From: Farhad Aarabi <fa[REDACTED]>
Sent: 25 October 2021 09:16
To: Amber Willard
Subject: Re: p/125/21/hh

I am the officer on your application P/125/21/HH at Neals Farmhouse.

1222-02

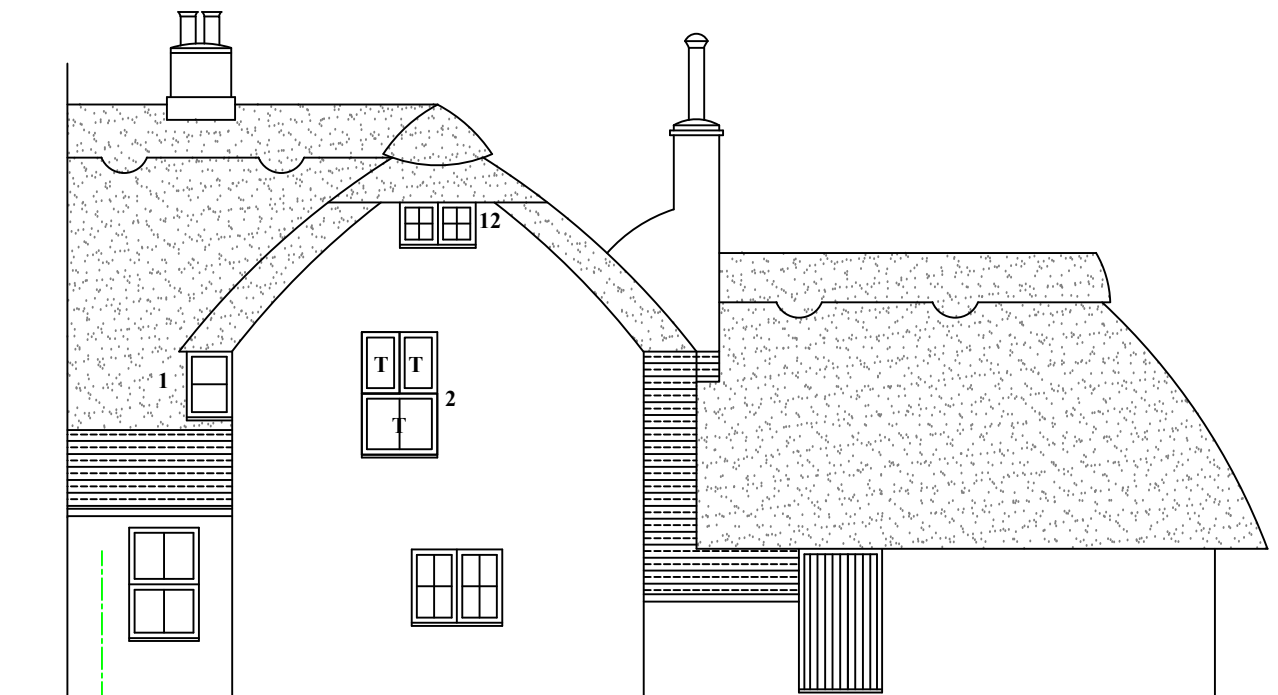
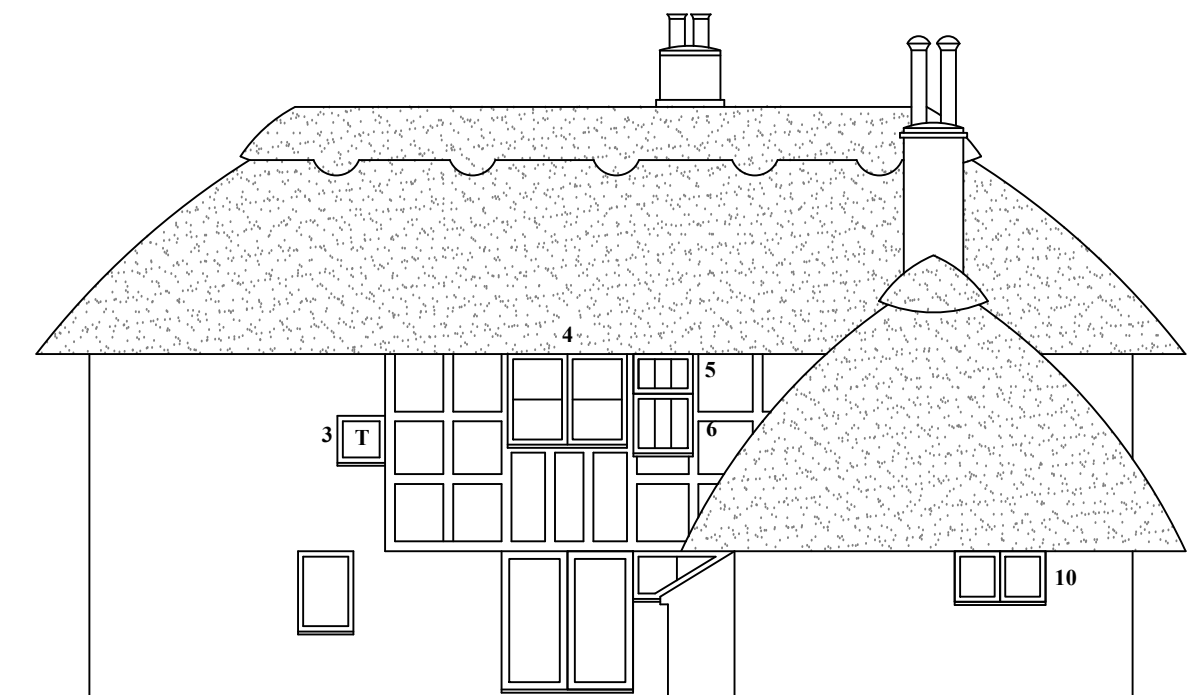
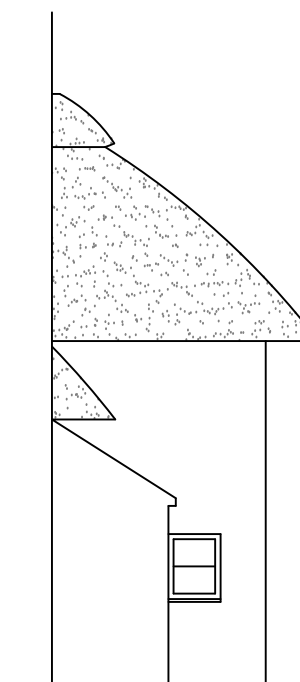
I have received some comments from the Conservation Officer which I attach and he does not believe the type of windows proposed are acceptable on the listed building. This should be considered before resubmitting and it may be helpful to have discussions with the Conservation Officer to ensure appropriate windows are proposed.
